Stonestreet Green Solar

Flood Risk Technical Note

PINS Ref: EN010135
Doc Ref. 8.18
Version 1
Deadline 5
April 2025

Figure 10.4

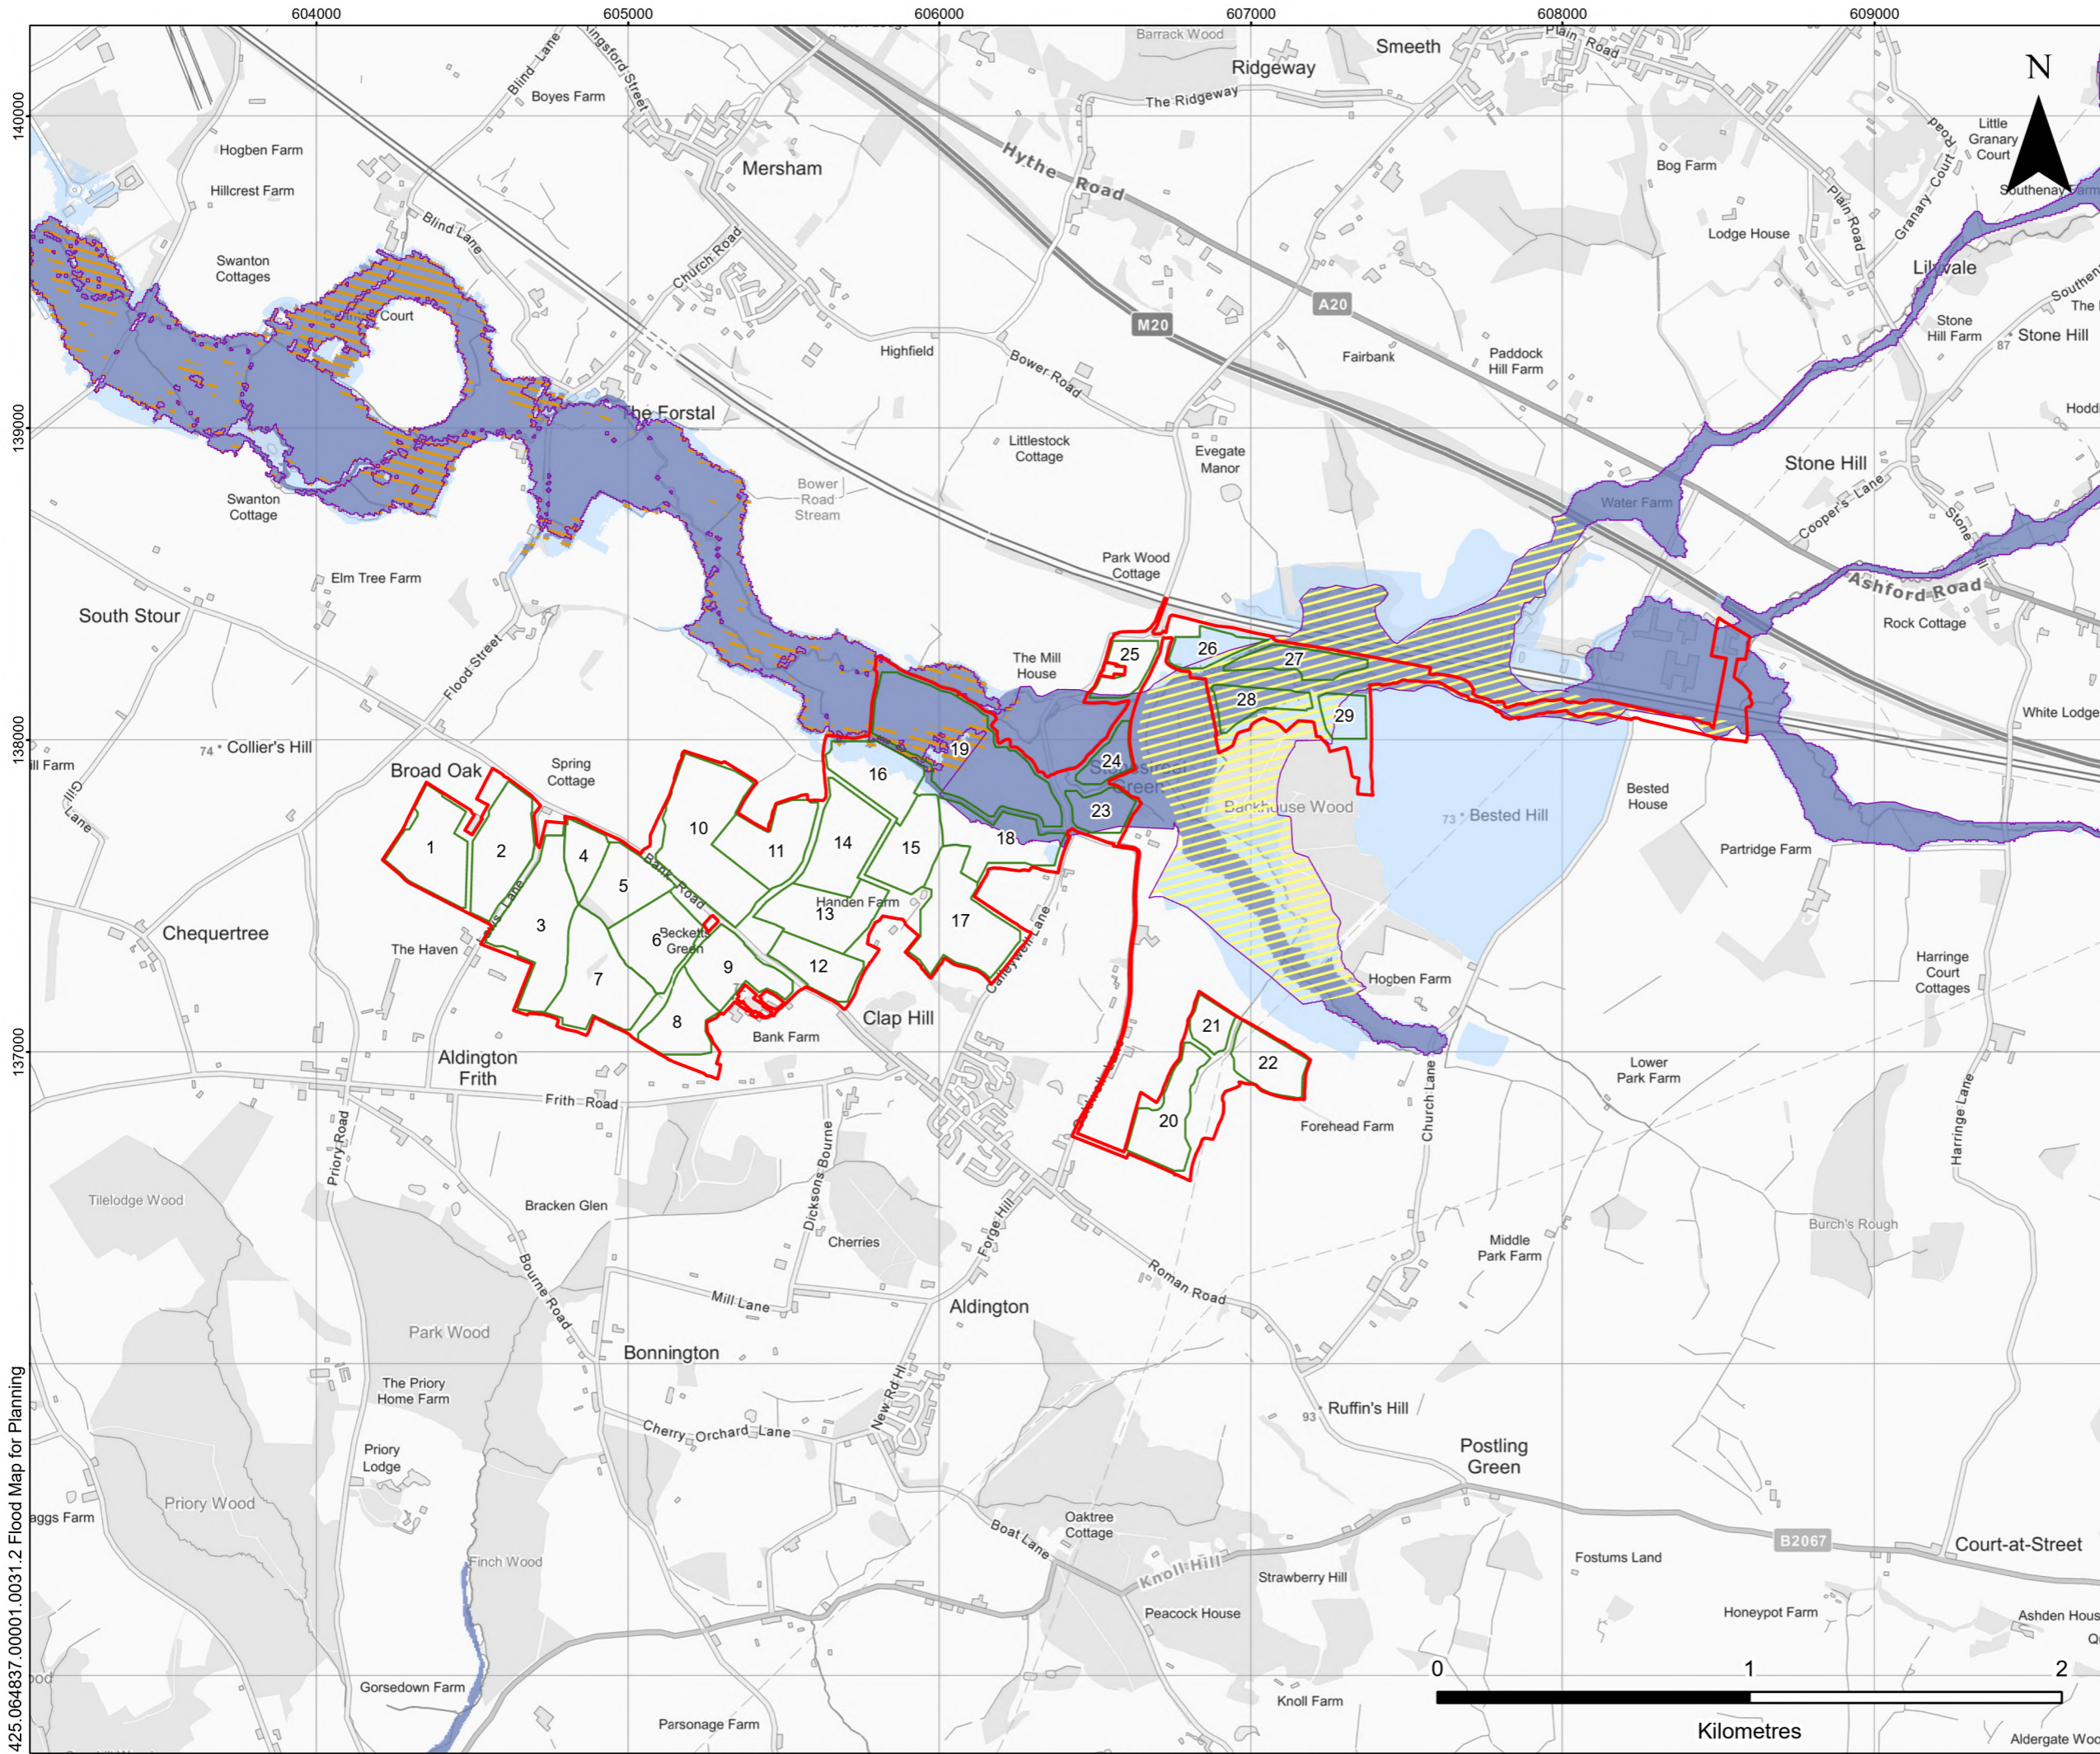
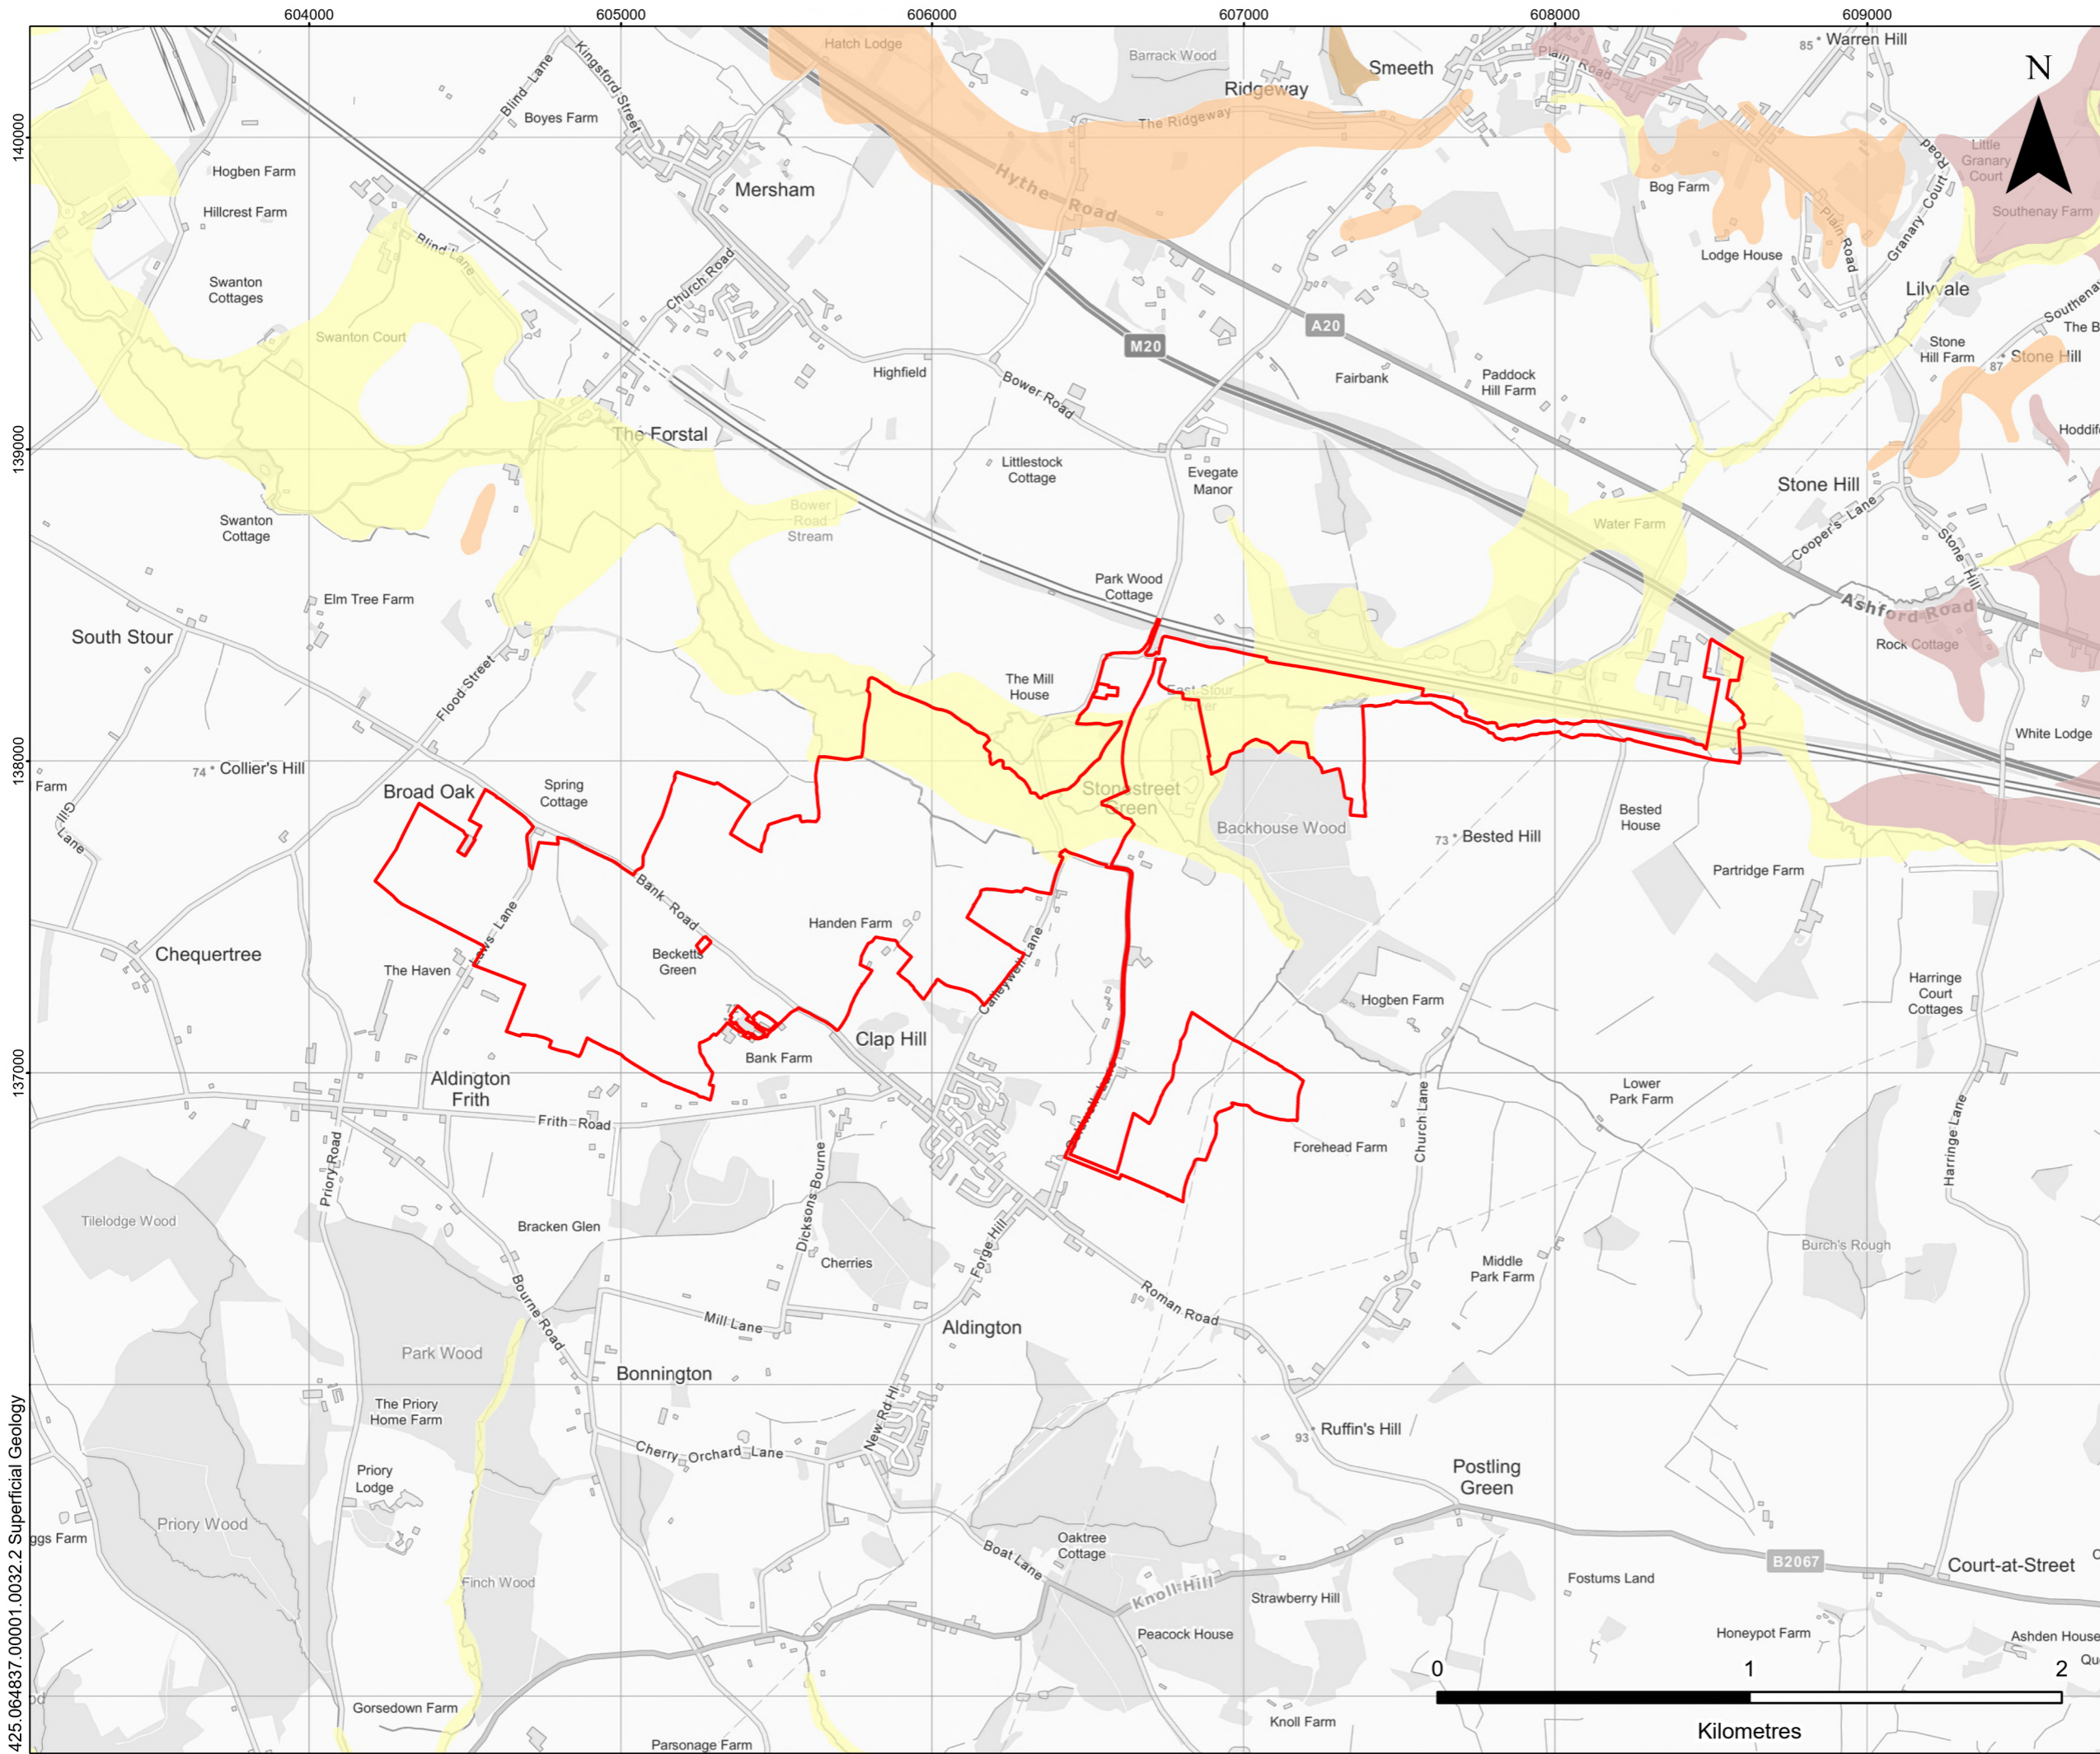
- 3.2.1 A number of the Figures included in the DCO Application have been updated and **replaced** to reflect the Updated FMP as set out in Table 3.1.

Submitted Versions:
Figure 10.4 of ES Volume 3, Chapter 10: Water Environment Figures 10.1-10.8 (Doc Ref. 5.3) [APP-052].
Figure 10.2.8 of ES Volume 4, Appendix 10.2: Flood Risk Assessment (Doc Ref. 5.4(A)) [REP1-036], [REP1-037] and [REP-038]

Flood Type	Change and Current Flood Risk
Flood Zones	<p>Figure 1.2 and Figure 1, Appendix B show the Updated FMP data compared to the submitted version (Figure 1.1) and shows:</p> <ul style="list-style-type: none"> ▪ The extent of Flood Zone 2 and Flood Zone 3 no longer overlap within the Site; ▪ There has been an overall reduction in the extent of Flood Zones 2 and 3 within and surrounding the Site; and ▪ There are no areas of the Site where Flood Zones have increased.
Long Term Flood Risk from River and Seas	<p>Figure 2.2 and Figure 2, Appendix B show the Updated FMP data compared to the submitted version (Figure 2.1):</p> <ul style="list-style-type: none"> ▪ There has been an overall reduction in the extent of long term risk of flooding from rivers or sea (when defences are operating); ▪ Areas which are likely to experience flooding from rivers and sea are the same as the areas located within Flood Zone 2 and 3; and ▪ There are no new areas at risk of long term flooding area identified within or adjacent to the Site. <p>Figure 1 Appendix A illustrates new data included in the Updated FMP and shows the Risk of Flooding from Rivers and Sea – Climate Change. This shows there is no significant change in fluvial flood risk for the Site and surrounding area when considering possible impacts of climate change on future flood risk.</p>

Replacement Versions:
Figure 10.4 of ES Volume 3, Chapter 10: Water Environment Figures 10.1 - 10.8 (Doc Ref. 5.3(A))
Figure 10.2.8 of ES Volume 4, Appendix 10.2: Flood Risk Assessment (Doc Ref. 5.4(B))

- 3.4.10 The EA's previous FMP was included within Appendix 2: Sequential and Exception Test of the **Planning Statement (Doc Ref. 7.6) [APP-151]**.
- 3.4.11 As Figure 1.2 shows, although there has been a reduction in the amount of the Site located within Flood Zone 2 and Flood Zone 3, the Site is still partially located within Flood Zone 2 and 3 and therefore the Sequential Test is still required.
- 3.4.12 The Updated FMP shows reductions in the areas of the Site and surroundings within Flood Zones 2 and 3. However, these reductions are not material to the Sequential and Exception Test of the **Planning Statement (Doc Ref. 7.6) [APP-151]** which remains valid.
